**Consultation Response from Mike Hibbert,  
 KC Waste Strategy( Refuse & Recycling)**

**2024/90072 land at, Bradley Villa Farm, Bradley Road, Bradley, Huddersfield, HD2 2JX**

**Discharge of conditions 13 (cycle parking), 14 (electric vehicle charging), 16 (waste management), 33 (air source heat pumps) and 36 (external lighting) of previous permission 2021/92086 for erection of 277 residential dwellings and associated infrastructure and access**

**Responding Ref: WPS 24-001**

TITLE:
BIN & CYCLE STORE DETAIL

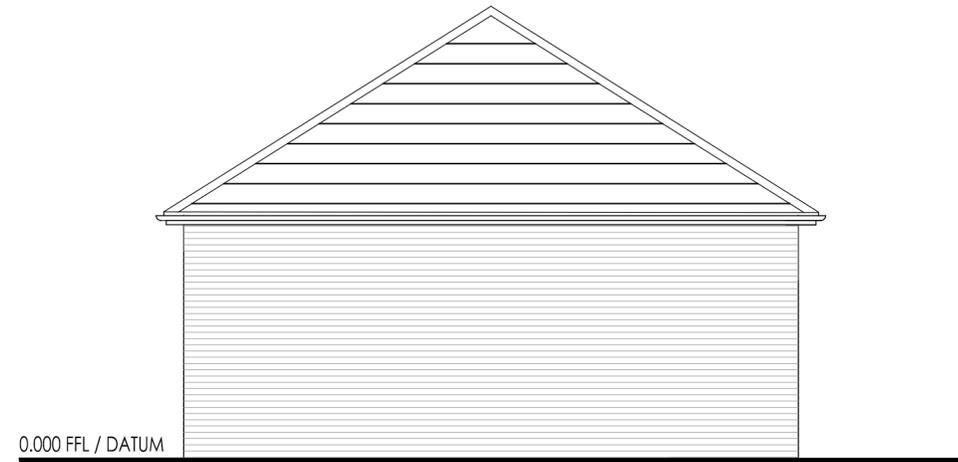
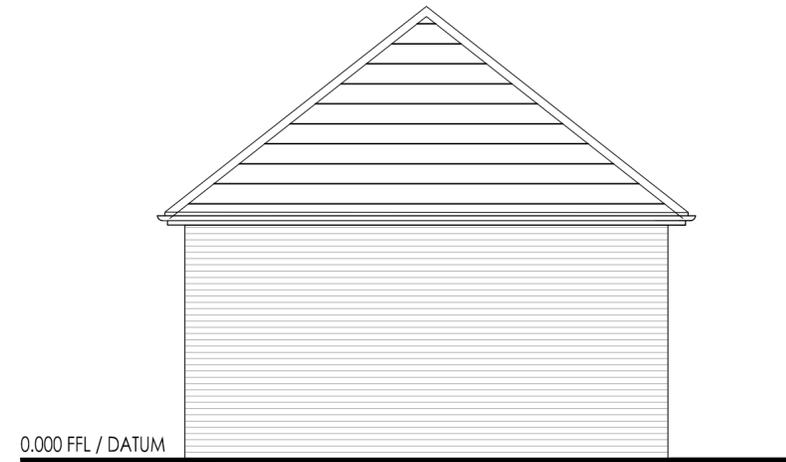
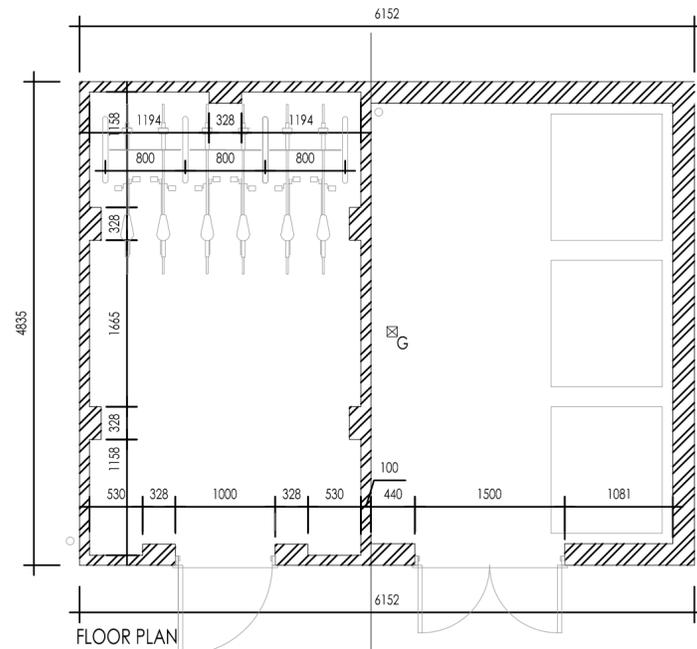
- There are Communal Bin Stores/Collection Points for Plots 191-199 and 200-204. Communal waste storage presents a fire risk and therefore must therefore comply with fire regulations (refer to BS 5906:2005 Waste Management in Buildings; Building Regs 2010 Part H6 and CFPA-E Guideline No 7:2022 F). Wheeliebins could be stored against the gable ends if there are no window openings above and the bins are contained within fire rated metal stores, otherwise guidance would indicate bins should be 6m from buildings.

- The communal waste store should be secure to prevent theft and unauthorised use/ fly tipping. If the gates to the bin store are to have a keypad to secure access these details will be required by the collection staff.

- Where communal bins are provided the drag out distance from the store to the highway/ BCP is 10m, that is the maximum specified in guidance and consideration should be given to relocating the bin stores closer to the highway. If individual bins are provided householders would need to present bins at a BCP on collection day.

- The bin store dimensions would depend on configuration and size of bins within the store. Additional information is required detailing waste storage, containers, capacity, and design of the waste storage compound including, screening, surfacing and security. Appropriate standards are detailed in the Kirklees Waste Management Design Guide 2020. Bin store surfaces should be durable and waterproof enough to withstand heavy duty cleaning such as power washing.

- The bin storage area and access routes to the Bin Collection Point (BCP) should be constructed to withstand point loading and movement, impacts of larger bins over time, and to resist future rutting, pitting, cracking or other such surface degradation that would impair bin manoeuvring. To facilitate loading of full wheeliebins the surface between the bin store and BCP/ highway should be smooth hard surface without kerbs.
